DECISION DELEGATED TO DEVELOPMENT MANAGER**DECISION DELEGATED TO DEVELOPMENT MANAGER**

Application No: H16-0821-20 **Applicant:** Mr & Mrs Hawtin
Proposal: Replacement of 5 windows to rear elevation.
Location: 21 London Road Spalding
Terminal Date: 19th May 2021

Typical Window Elevation
Scale 1:20

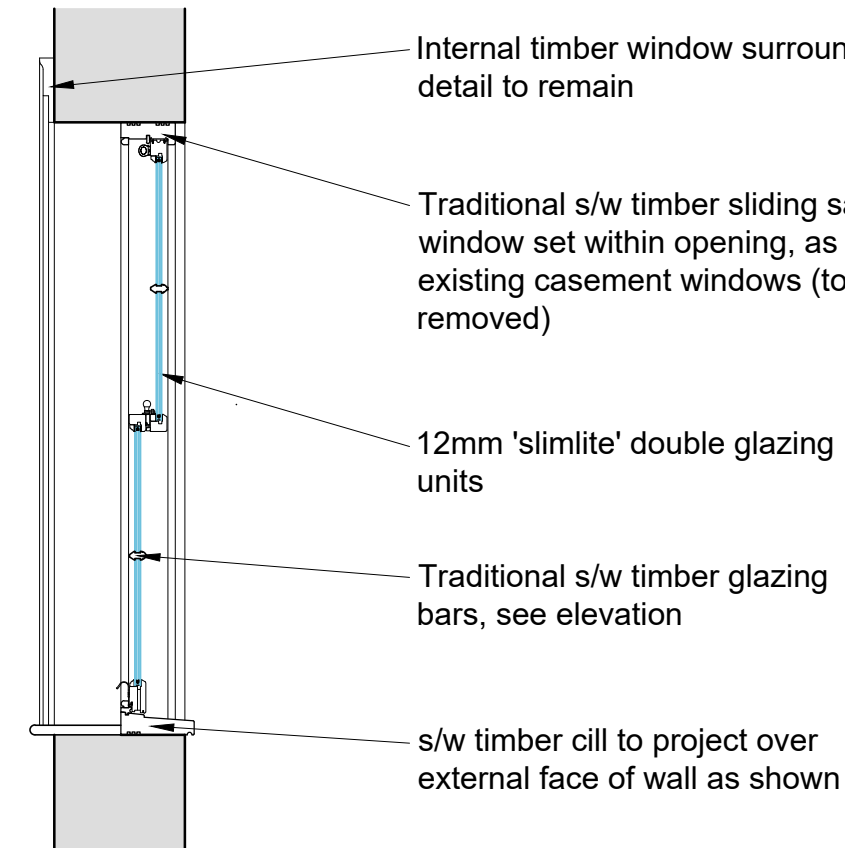
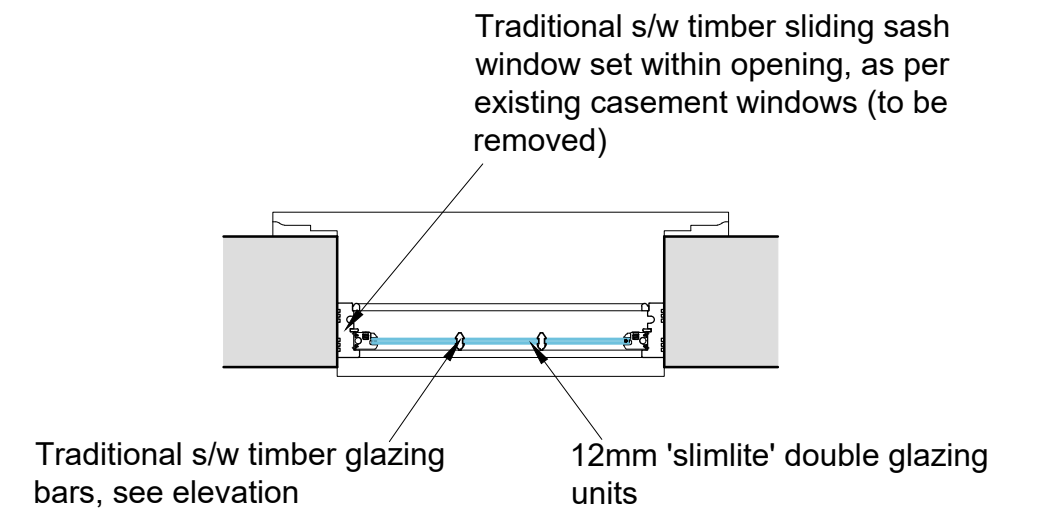
The removal of the extant 20th century, inappropriate windows is acceptable. However, the proposed replacement windows are of an inappropriate style to the Grade II* listed nature of the site. The windows should not feature horns as this is not period appropriate to the property. The windows should be of a vertically hung style rather than the proposed balanced spring style.

The applicant considered the comments of Historic England and has amended their plans accordingly.

Typical Window Elevation
Scale 1:20

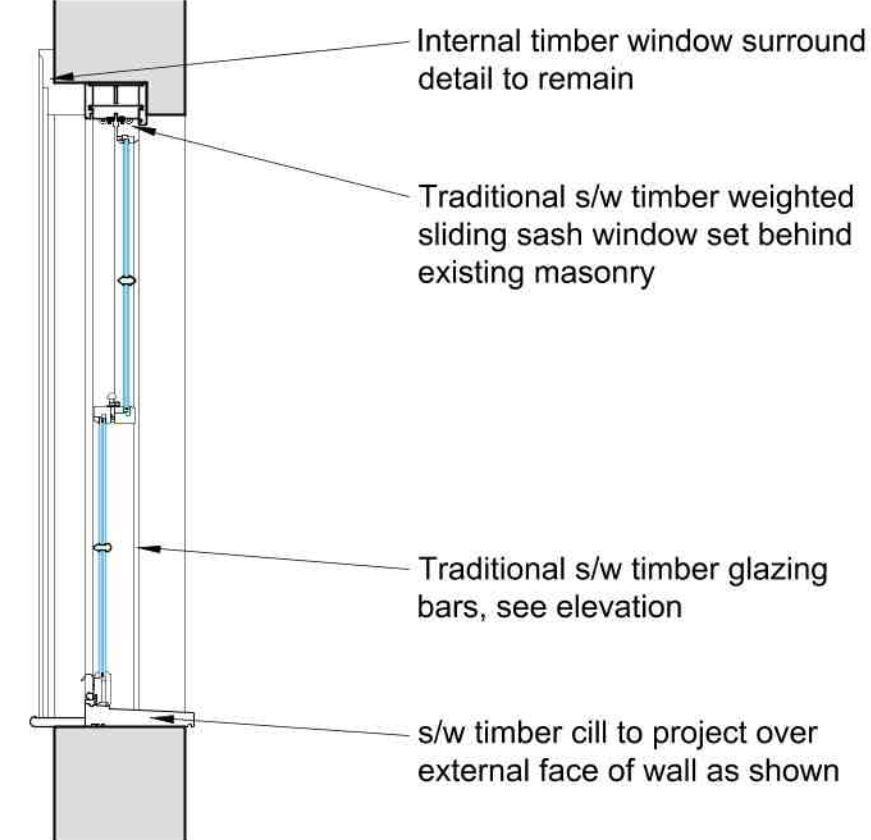
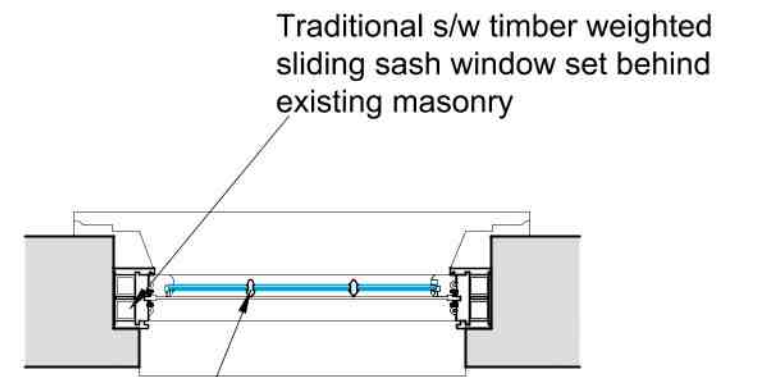
The relief of the windows within the window reveals needs to be considered.
